Planning & Urban Development Department

April 11, 2014

RE: 478 Island Ave - 90-J-001 and 60 Oaklawn Ave – 90-J-002 & 90-J-009, Peaks Island

**PROPOSED NEW LOT CONFIGURATION OF LAND
478 ISLAND AVENUE AND 60 OAKLAWN ROAD
PEAKS ISLAND, PORTLAND, CUMBERLAND COUNTY, MAINE**

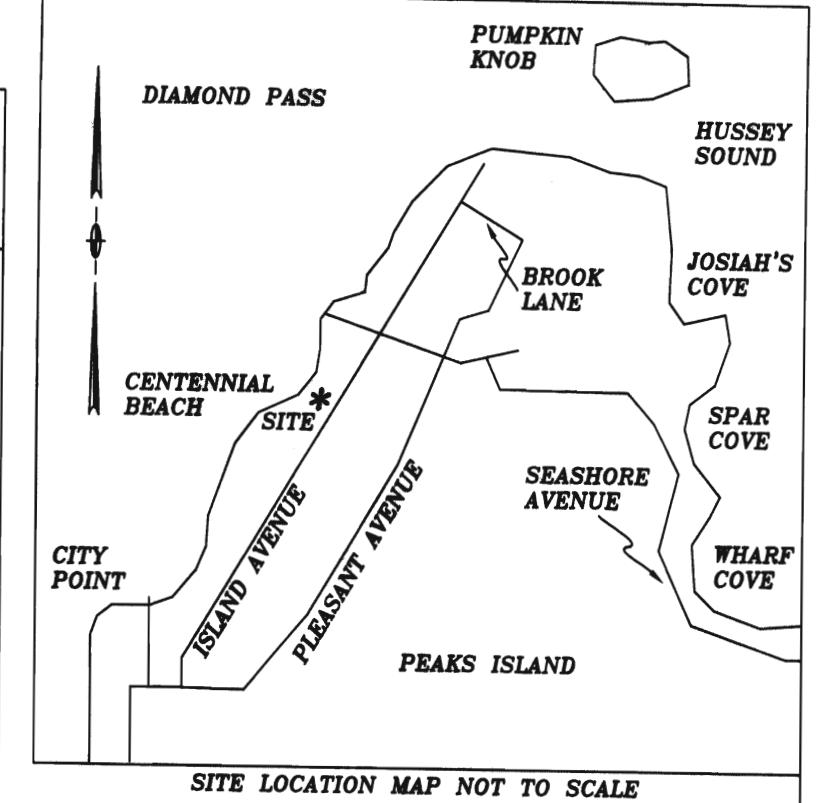
The redefined property lines result in two lots, Beach House at 60 Oaklawn Road, and Top Side at 478 Island Avenue. Both of the new lots are meeting the minimum land area requirements of 20,000 square feet. The proposed division line results in both lots meeting the minimum setback requirements as affected by the new division line. I have determined that the new division line does not create any non-conformity under the Land Use Zoning Ordinance. It is further understood that the 8'x12' shed will be relocated as shown on the Beach House property and meets the dimensional requirements of the IR-2 Zone.

The survey also shows a phase II proposed future garage addition on the Beach House property. I have determined that what is depicted will not violate the IR-2 Land Use Zoning Ordinance. However, this determination is not a final approval to begin construction on this proposed garage. Separate application(s), review(s) and approval(s) will be required prior to any work commenced.
